CITY OF ALBUQUERQUE

August 26, 2019

Re: Maverik 98th & Bluewater
9701 Bluewater Rd NW
Traffic Circulation Layout
Engineer's/Architect's Stamp [REDACTED] (K09D044)

RONALD R. BOHANNAN P.E. #7868	MAVERIK STORE #NM- 98th ST AND BLUEWATER RD	DRAWN BY pm
	TRAFFIC CIRCULATION PLAN	DATE 10-29-19
	TERRA WEST, LLC 5571 MIDWAY PARK PL NE ALBUQUERQUE, NEW MEXICO 87109 (505) 858-3100 www.tierrawestllc.com	DRAWING 2018086-SP
		SHEET # SP-1 JOB # 2018086

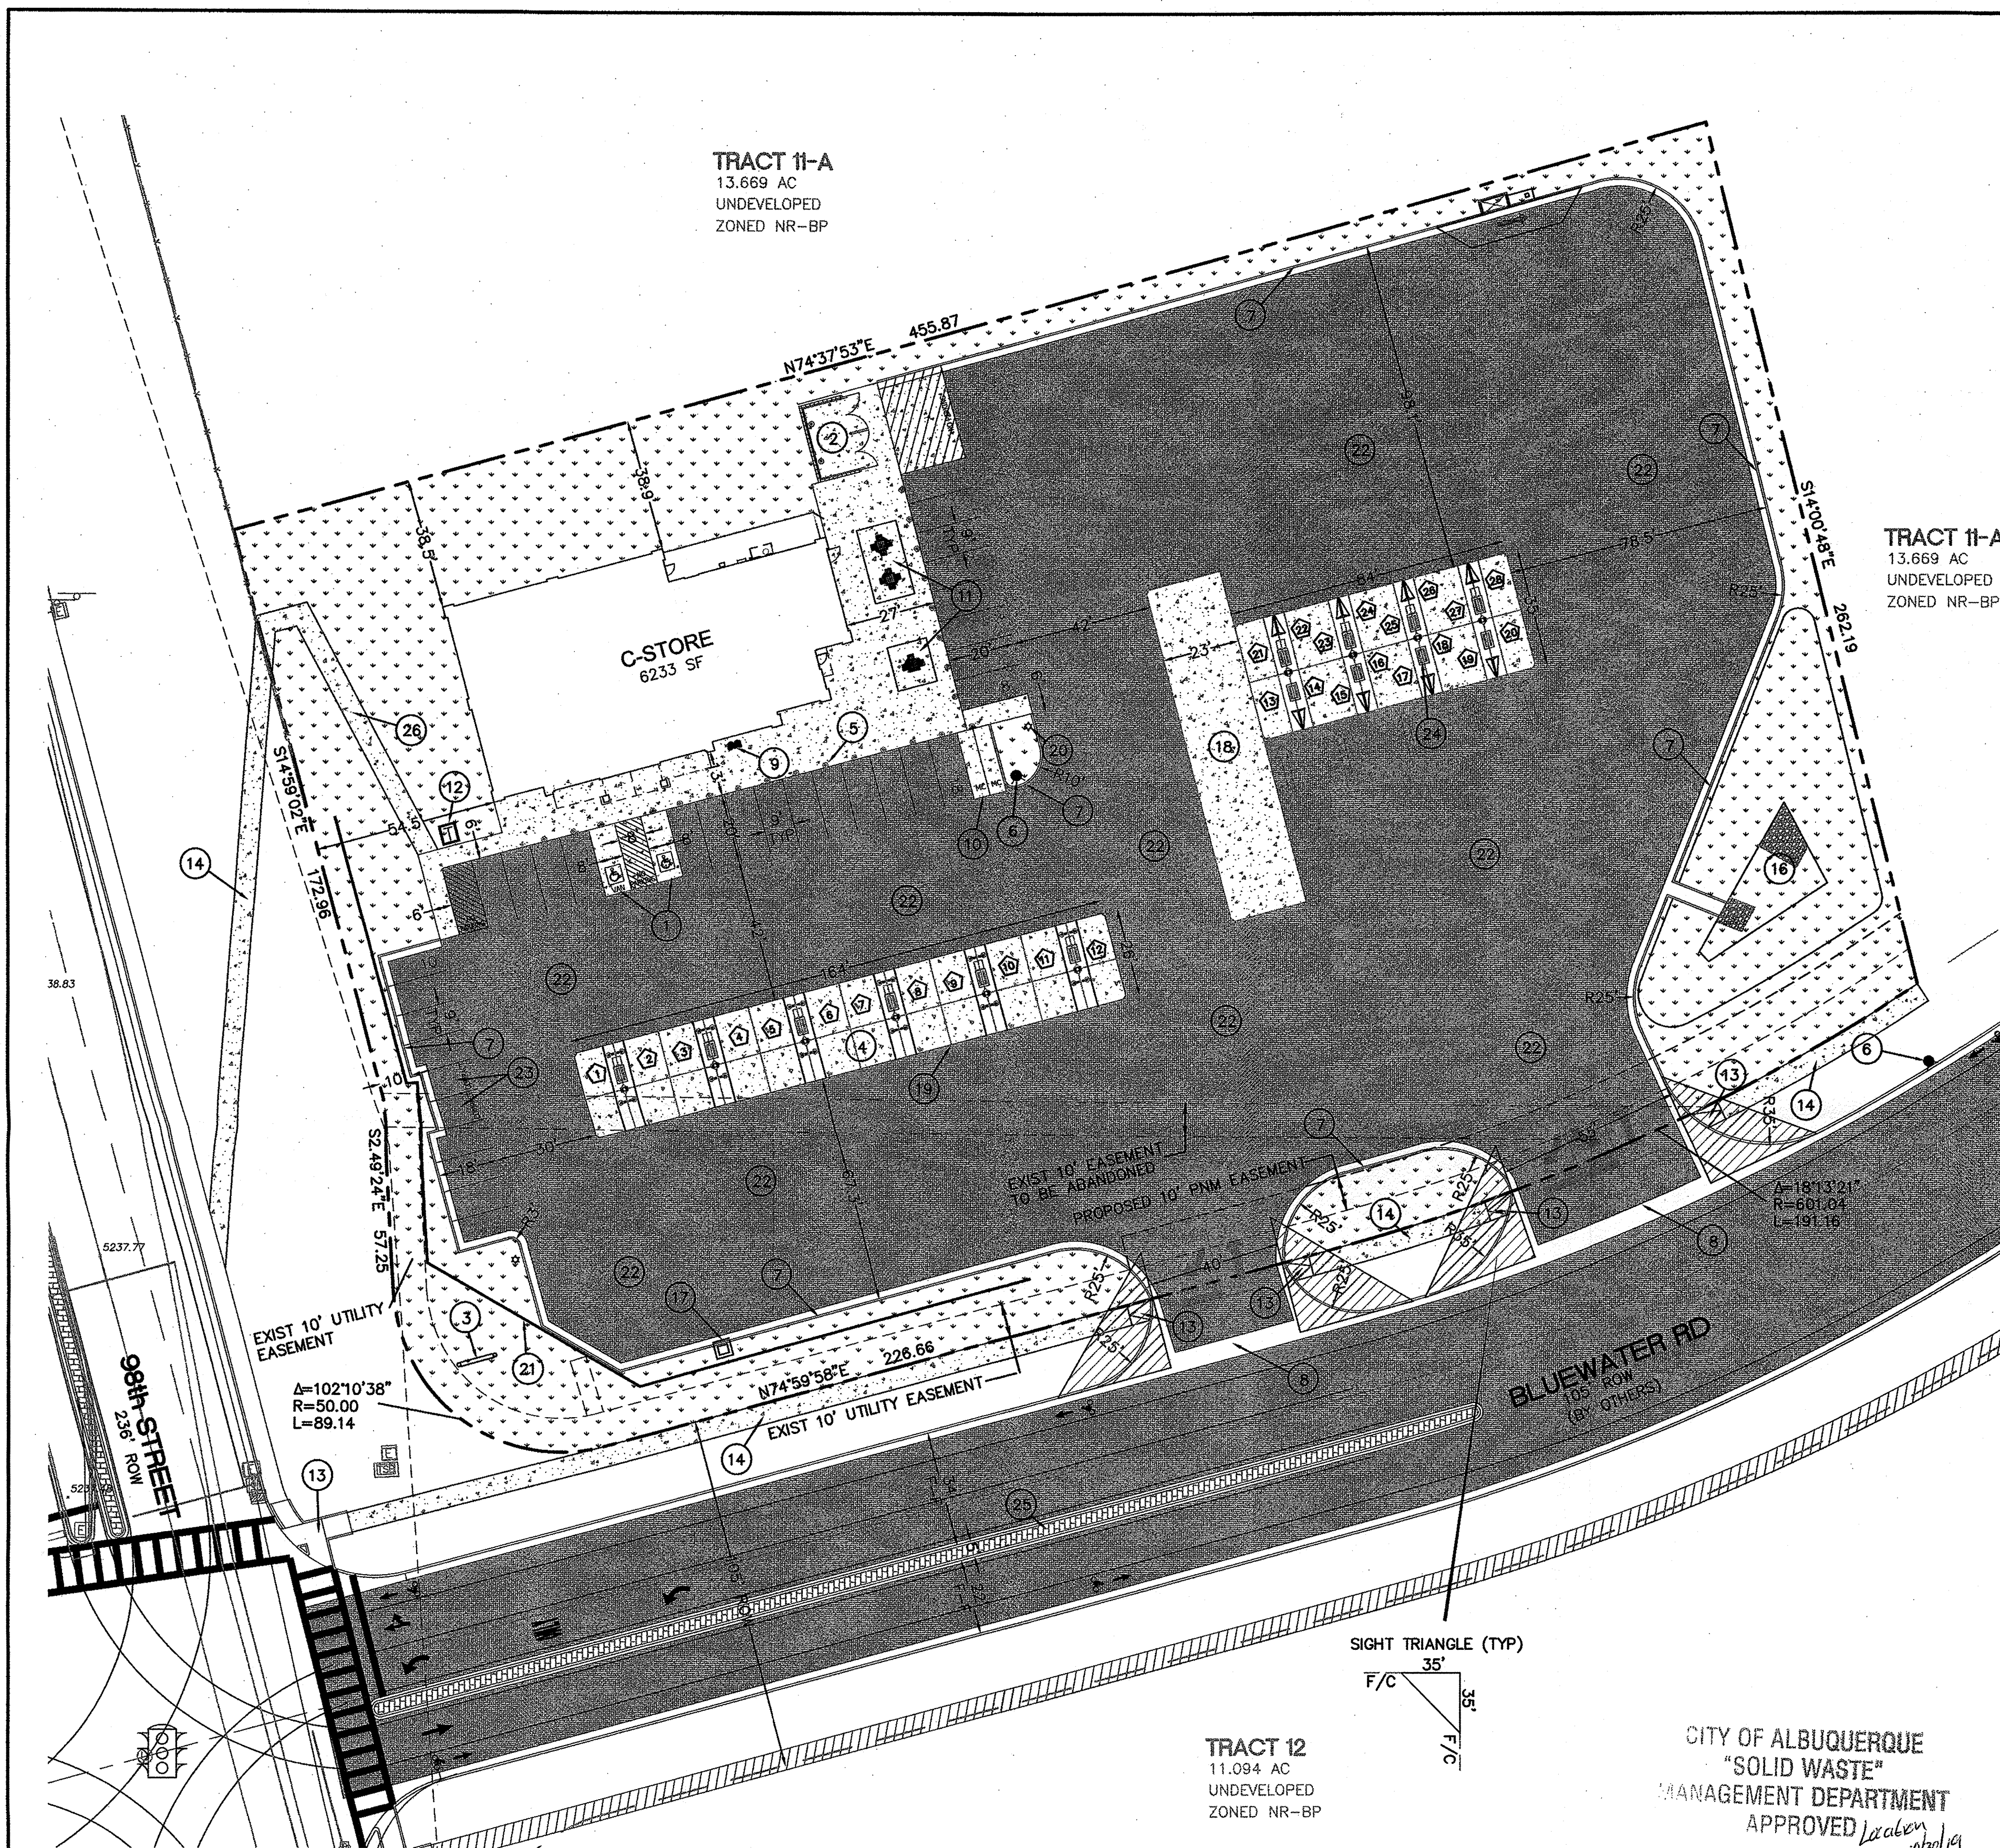
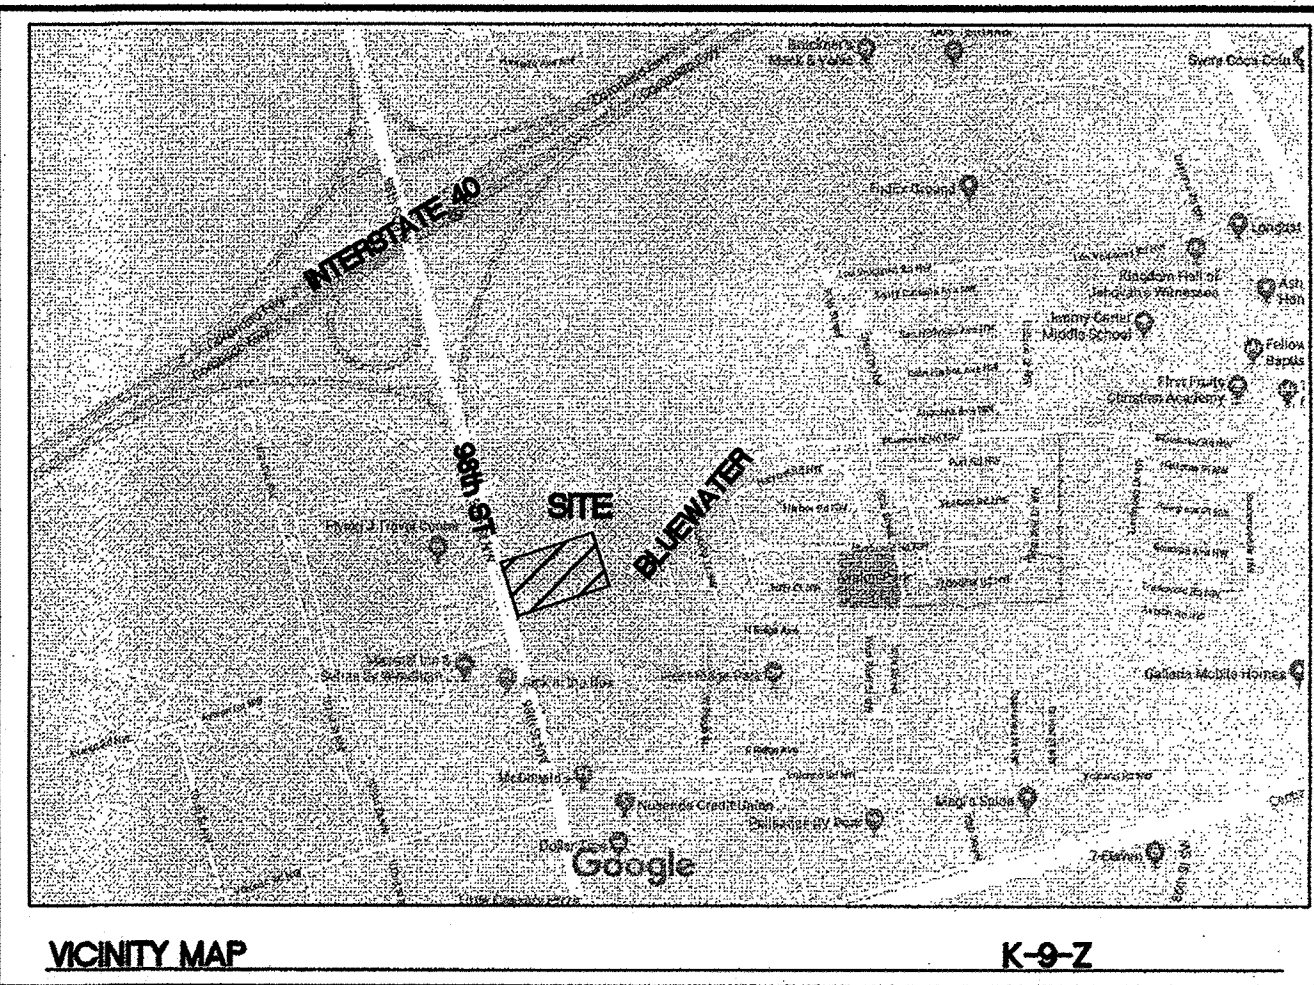
1. The traffic circulation layout must be stamped, signed, and dated by an engineer or architect licensed in the state of New Mexico.
2. Clarify existing property lines and proposed property lines. A replat needs to be done.

9. Show all drive aisle widths and radii. Some dimensions are not shown.
10. Per DPM, a 6 ft. wide ADA accessible pedestrian pathway is required from the ADA parking stall access aisles to the building entrances. Please clearly show this pathway and provide details.

11. provide a copy of refuse approval.
12. It is not apparent what type of pavement surface is being proposed. A hard driving surface will be required as part of this proposed project for parking area and drive aisles.

13. All one-way drives shall have "One Way" and "Do Not Enter" signage and pavement markings. Please show detail and location of posted signs and striping.

14. add the following note to the plan: "Landscaping and signage will not interfere with clear sight requirements. Therefore, signs, walls, trees, and shrubbery between 3 and 8 feet tall (as measured from the gutter pan) will not be acceptable in the clear sight triangle.

15. The TIS shows 17 fueling station, but the TCL shows 24 fueling station. Please clarify!
16. The keyed note #5 (truck fueling island) is pointing at a wrong thing. Please show where the truck fueling islands are!

17. Keyed note #14: at DRC, it was mentioned that the sidewalk along bluewater will be built by others. Please distinguish between the sidewalks that are being built by this project and the one that is being built by others.

18. The 15 ' radius of the curve is suitable for smaller cars. For trucks, the radius should be 25'.

ACCESSIBLE PARKING SIGN

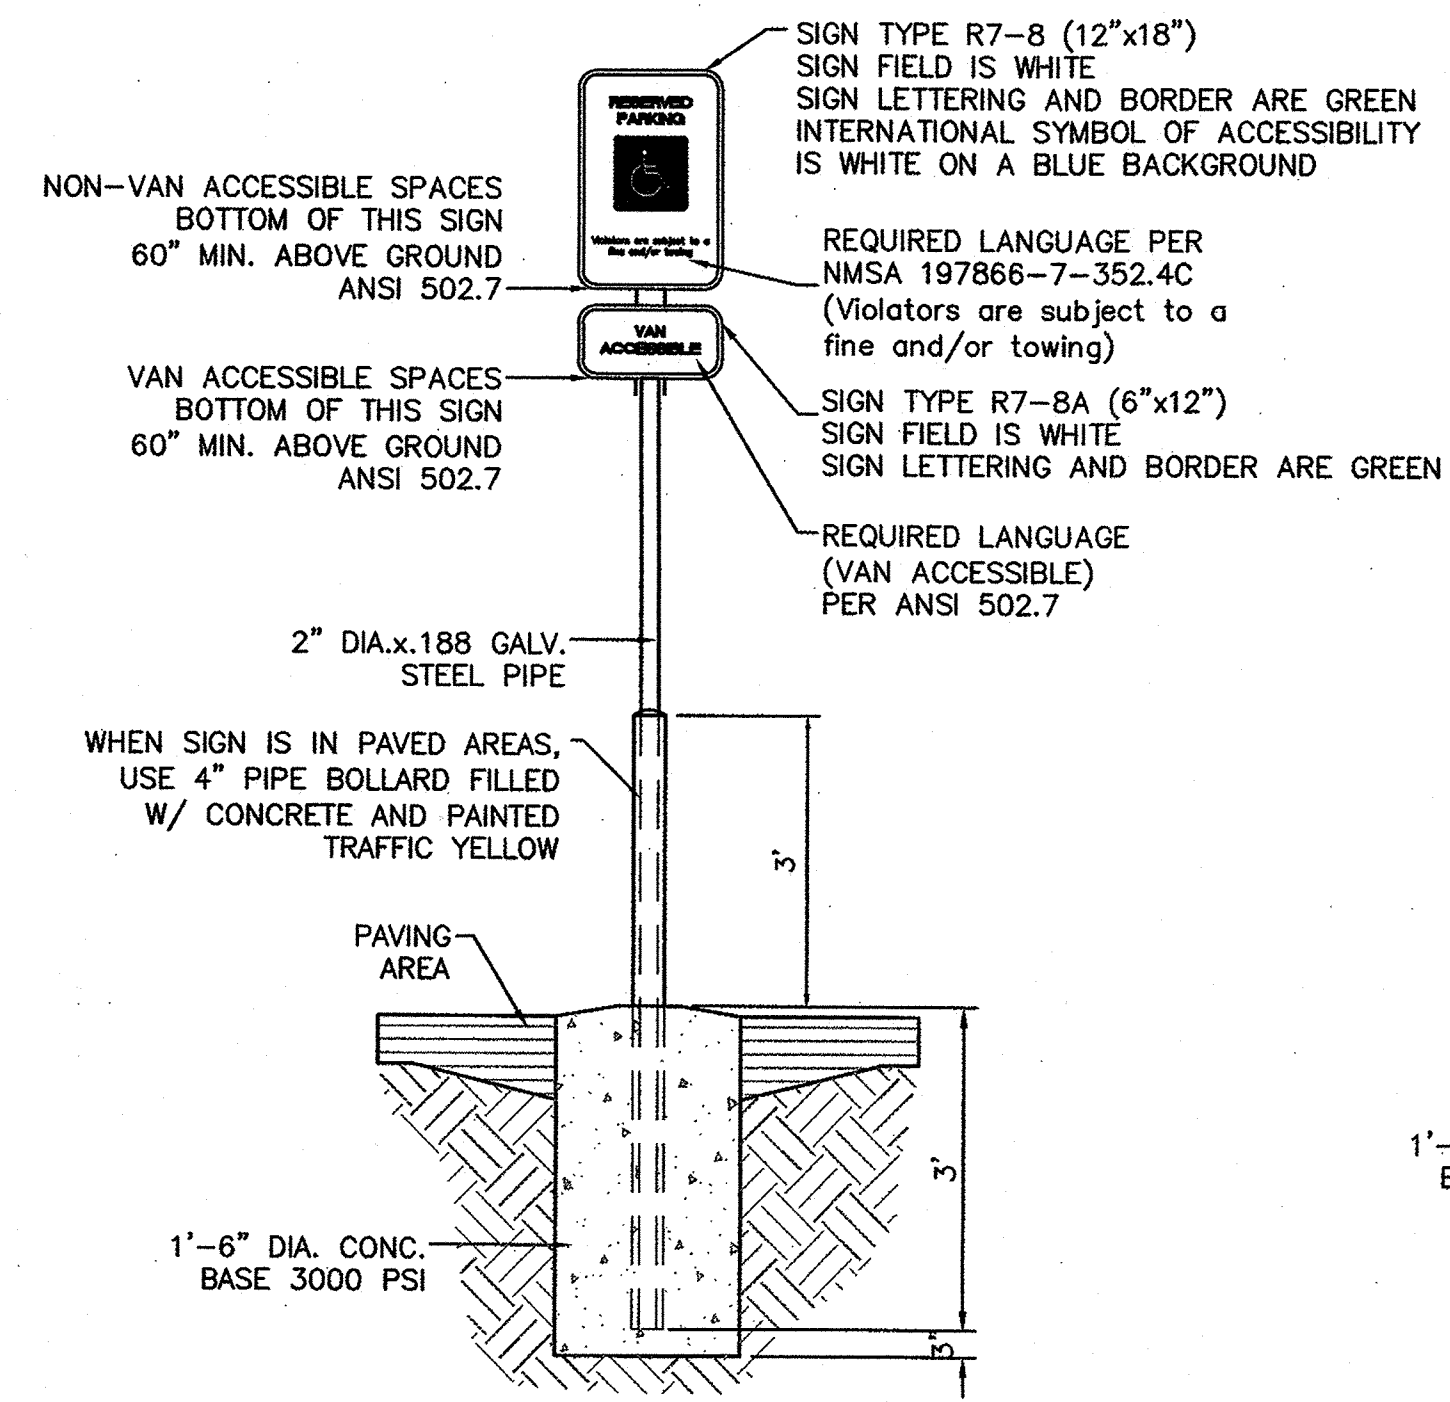
3. The ADA accessible parking sign must have the required language per 66-7-352.4C NMSA 1978 **"Violators Are Subject to a Fine and/or Towing."** Please call out detail and location of signs.

MOTORCYCLE PARKING SIGN

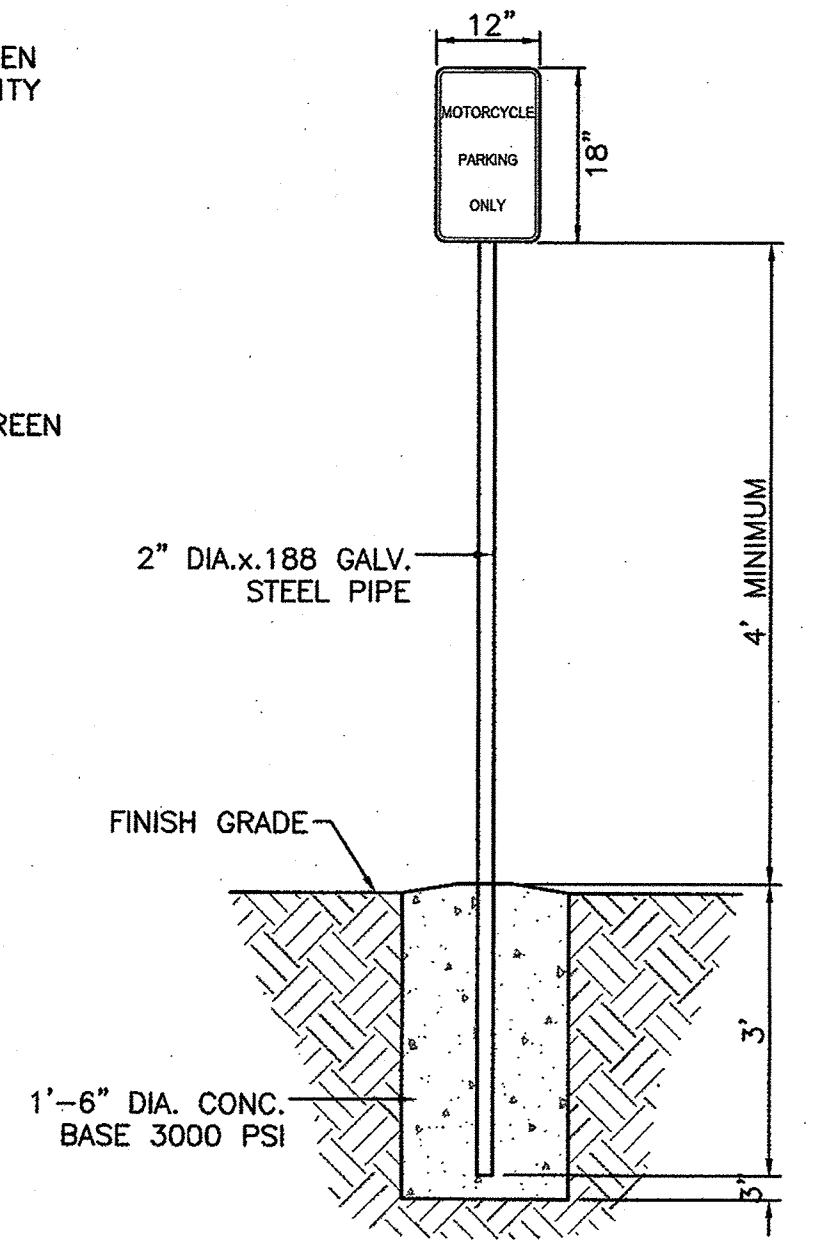
4. Motorcycle parking spaces shall be designated by its own conspicuously posted upright sign, either free-standing or wall mounted per the zoning code.

BIKE POST DETAIL

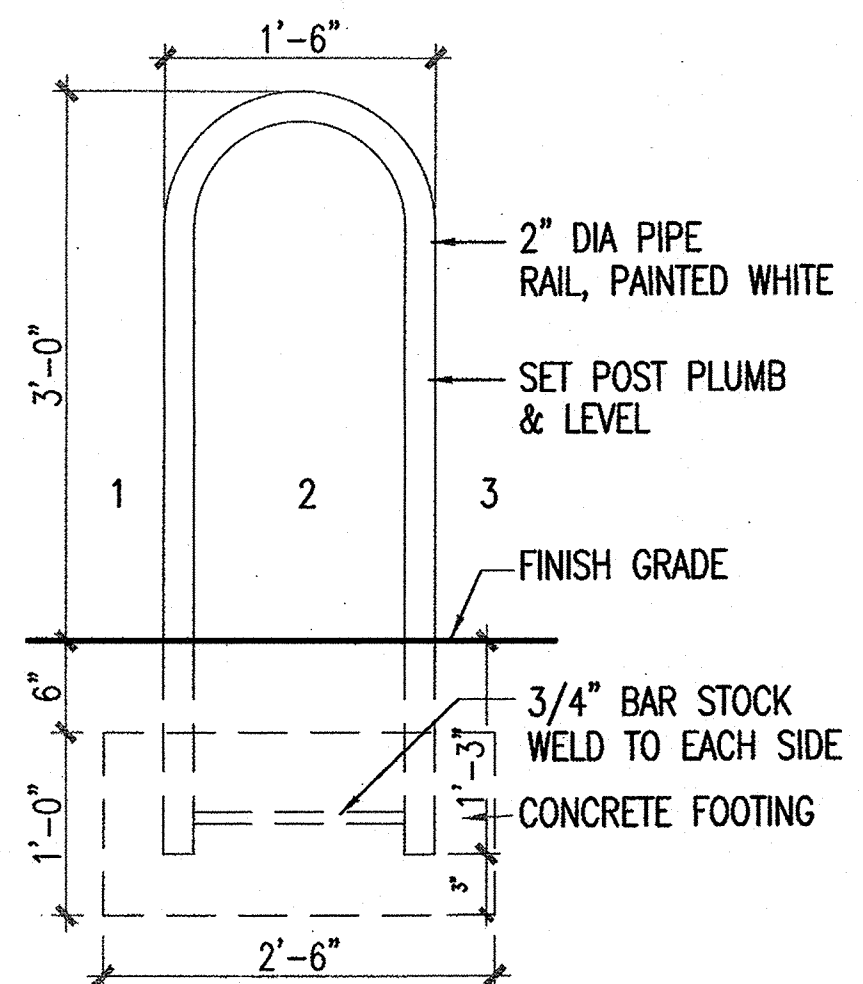
5. All bicycle racks shall be designed according to the following guidelines:
 - a. The rack shall be a minimum 30 inches tall and 18 inches wide.
 - b. The bicycle frame shall be supported horizontally at two or more places. Comb/toaster racks are not allowed.

- c. The rack shall be designed to support the bicycle in an upright position. See the IDO for additional information.
 - d. The rack allows varying bicycle frame sizes and styles to be attached.

- e. The user is not required to lift the bicycle onto the bicycle rack.
 - f. Each bicycle parking space is accessible without moving another bicycle.

6. Bicycle racks shall be sturdy and anchored to a concrete pad.
7. A 1-foot clear zone around the bicycle parking stall shall be provided.
8. Bicycle parking spaces shall be at least 6 feet long and 2 feet wide.
